## KITTITAS COUNTY COMMUNITY DEVELOPMENT SERVICES

### **Subject: Swauk Valley Ranch (LPF-18-00003) Final Plat. – Staff Review and Request for Additional Information**

Date: 3-28-18
Scale: 1"=200'
Drawn By: JG
Surveyed By: JG/TB
Checked By: JG
Sheet 1 Of 3
Job Number: 2016-SWK

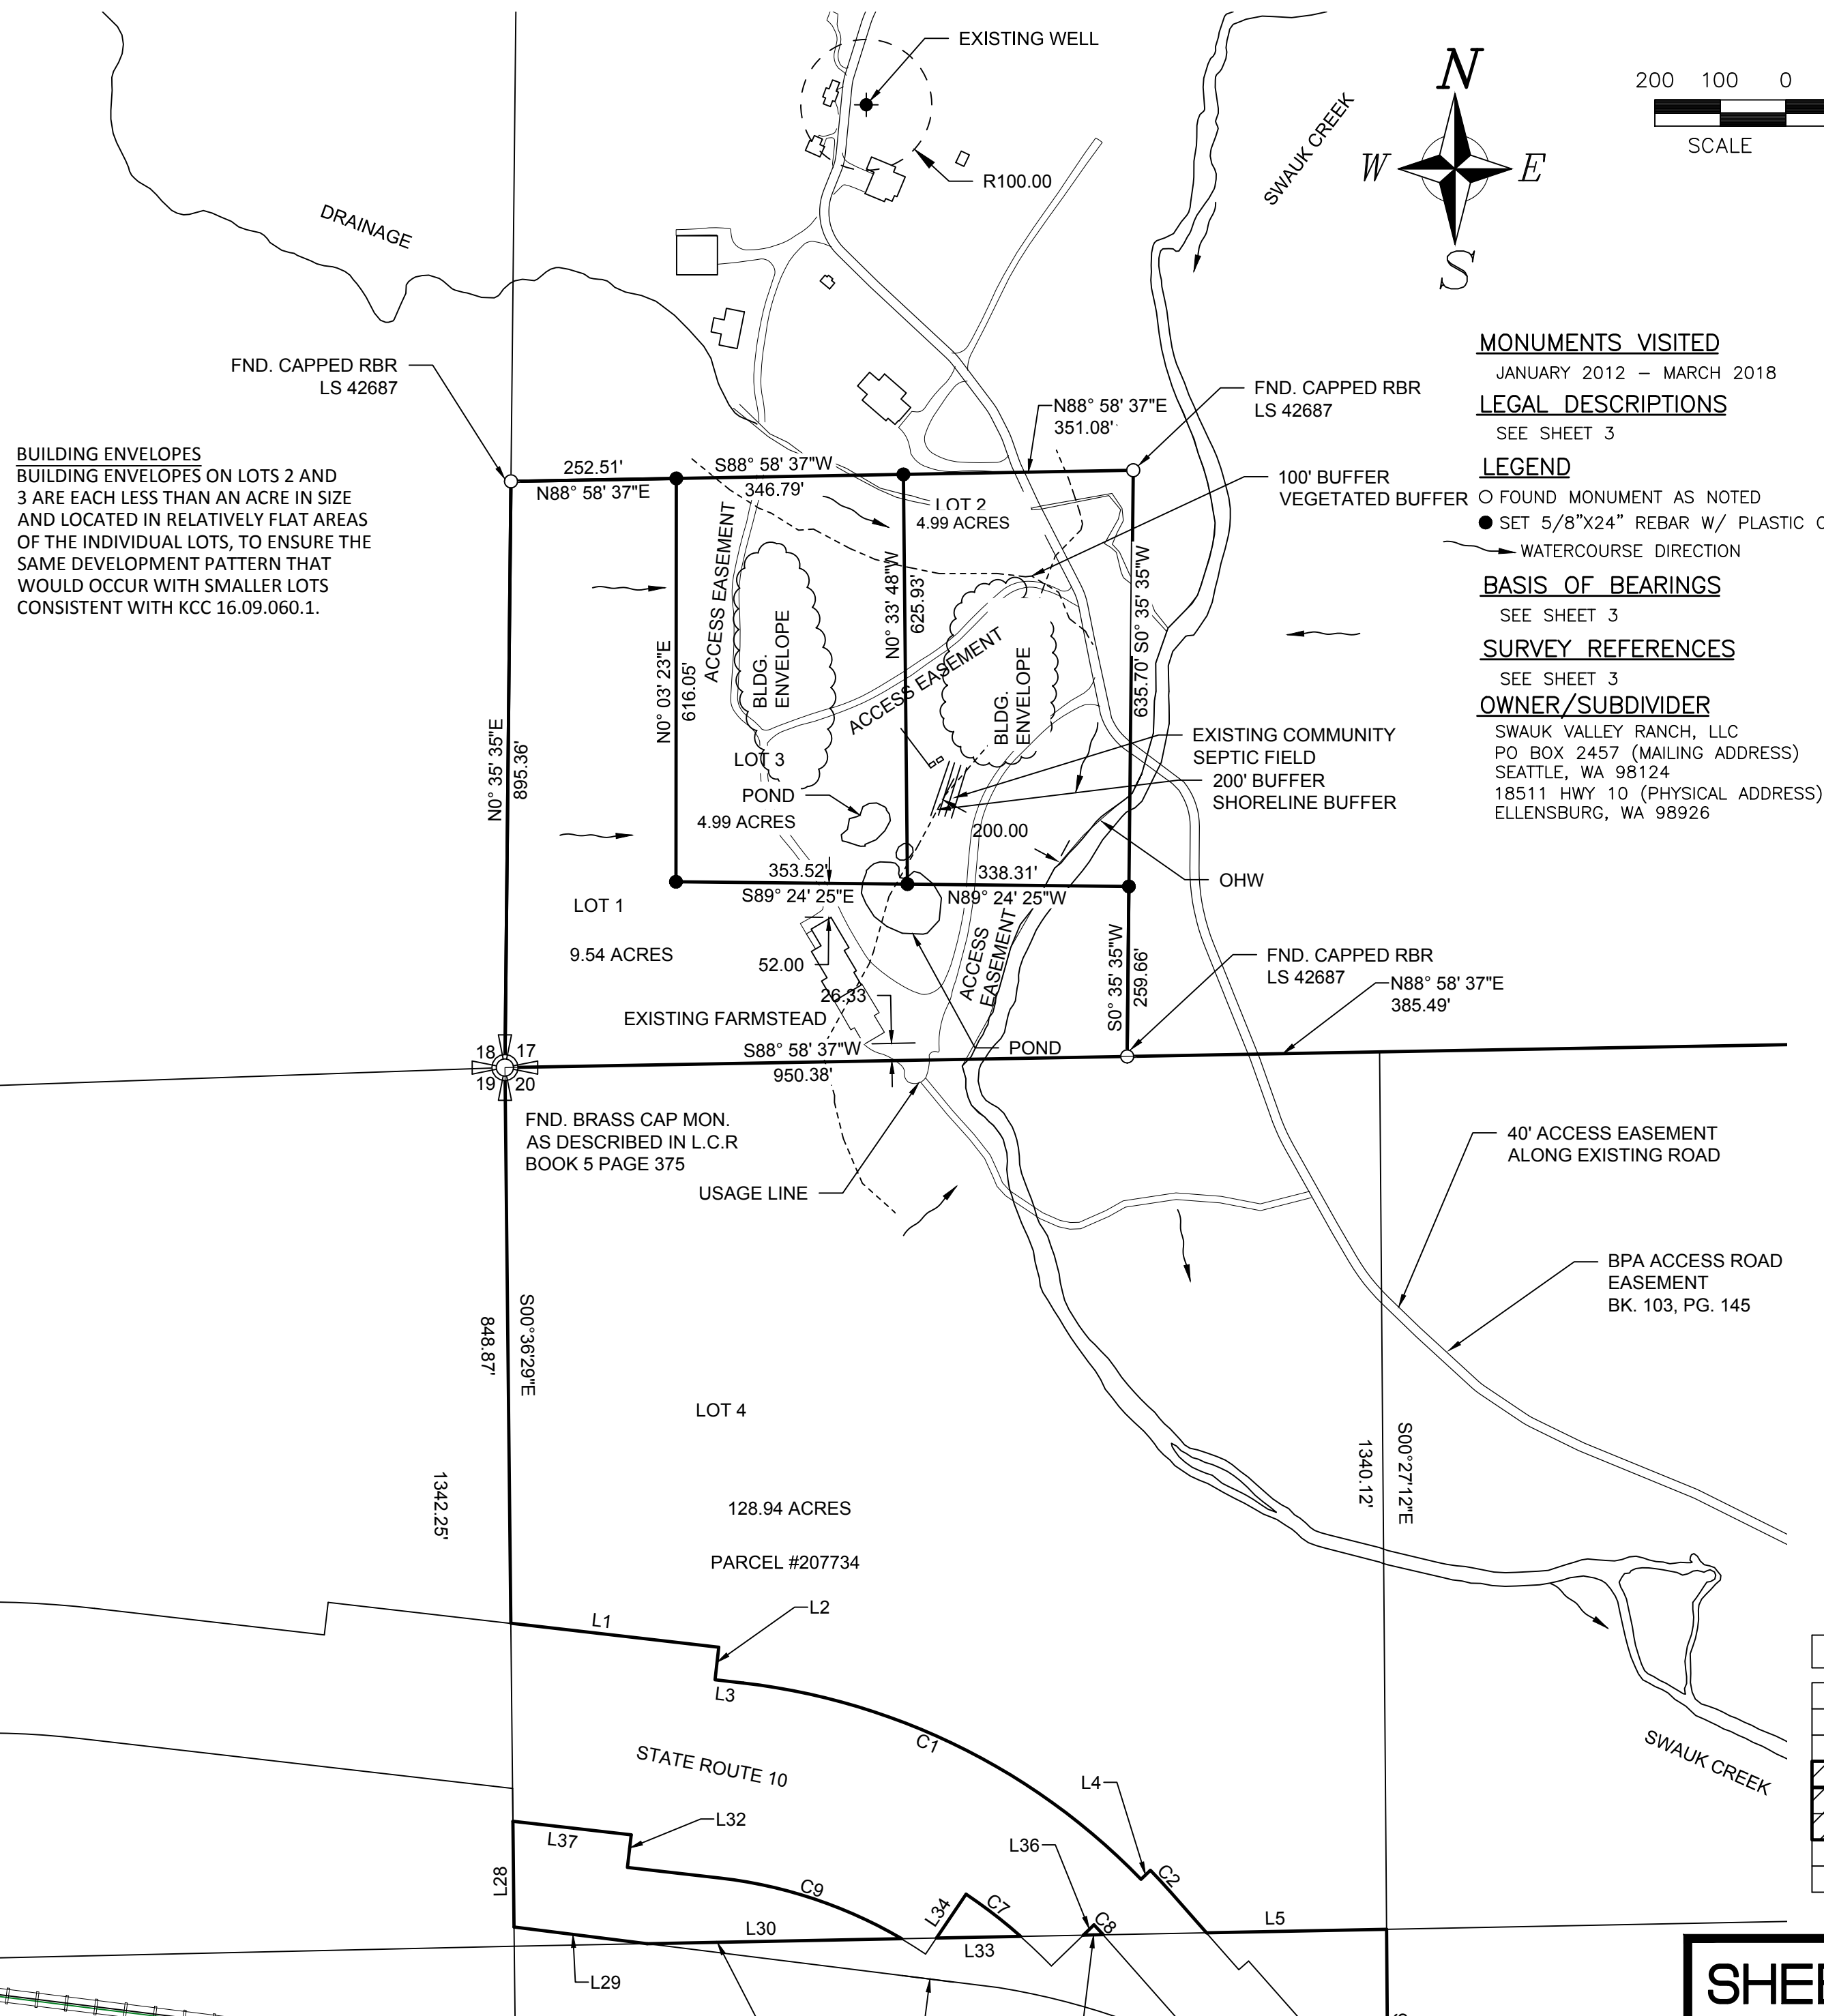
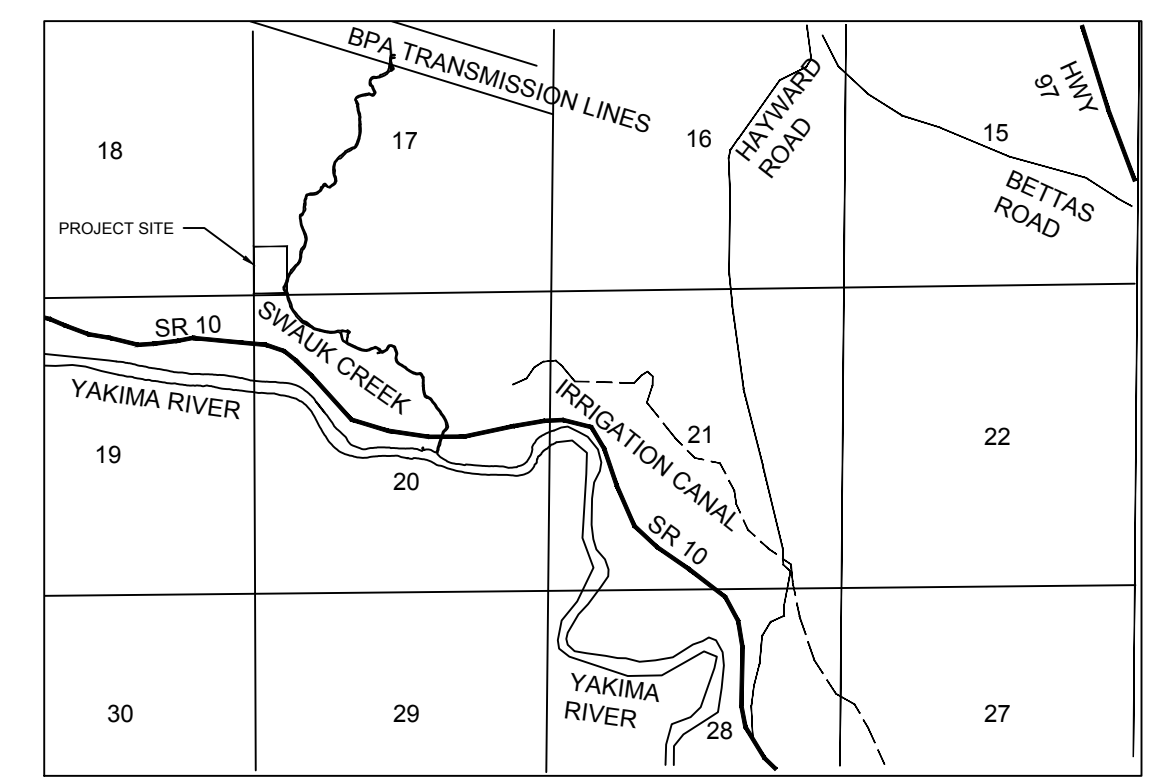
- 6) The access easement shall be addressed as existing or herein dedicated. If existing, the recording number shall be included, and if dedicated, the position shall be mathematically traceable.
- 7) The roads identified as private roads on lots 1-3 shall be revised to include easements to provide legal access to the new parcels.
- 8) The BPA access road shall be identified as where it begins and the 40' Access easement ends (or overlaps identified). The 40' Access road shall include the recording number of the easement document.

- 9) The area north of parcels 1 and 3 identified as R100.00 shall be identified. Additionally, if this well is to serve lots 1-3, easements shall be shown connecting said parcels to the well.
- 10) The building on Lot 1 shall show distances to the North and South property lines to ensure it meets setback requirements.
- 11) It appears that a portion of Lot 4 is being used by Lot 1. This usage shall be identified.
- 12) There are portions of Lot 4 that fall south of SR10. As these portions are a part of the land to be divided, they shall be delineated. The railroad right of way may also contain a small sliver of the largest undelineated parcel.
- 13) One of the corners of Lot 3 shows it as being set in a pond.

SHEET 2 OF 3

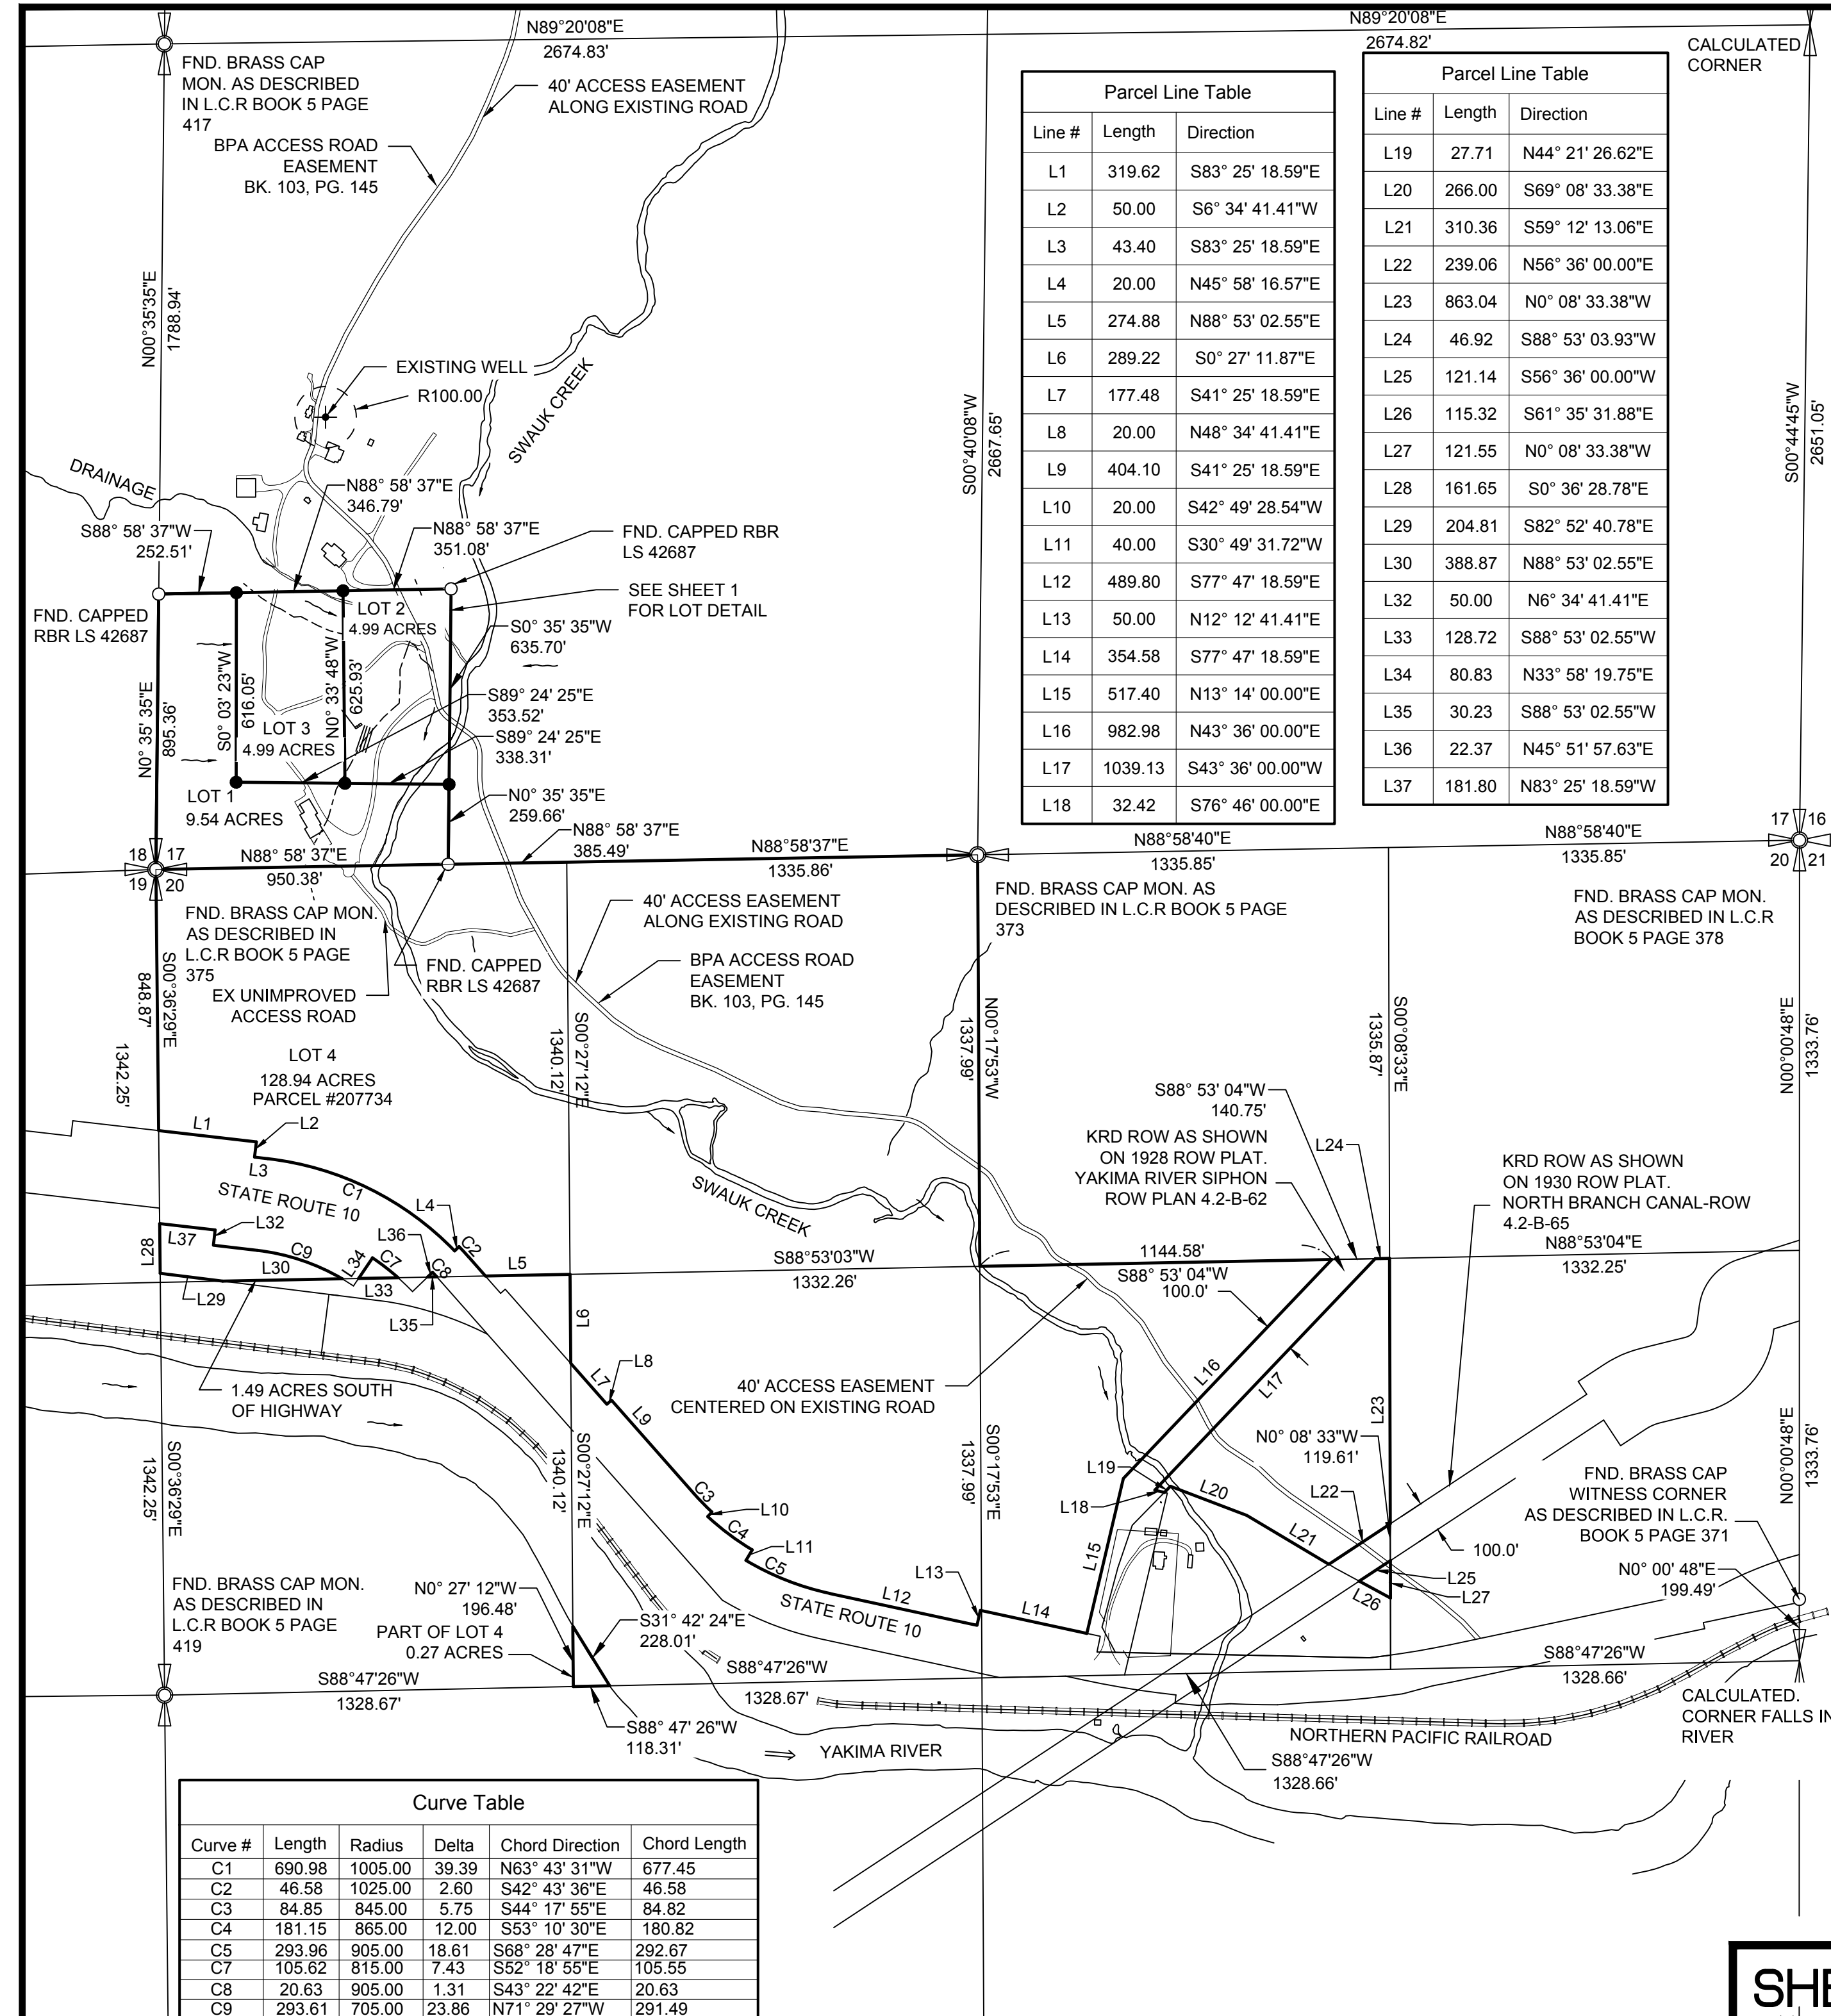
- 14) The leader arrow to the Witness corner at E1/4 of Sec 20 does not point to the witness corner.
- 15) There appears to be usage across Parcel 4 by the adjacent parcel to the East, near line 16. Usage lines shall be identified. This same parcel appears to be outlined and overlaps onto Lot 4 or the KRD r/w. This should be identified.
- 16) The closure reports do not match the radii as shown on the curve table.
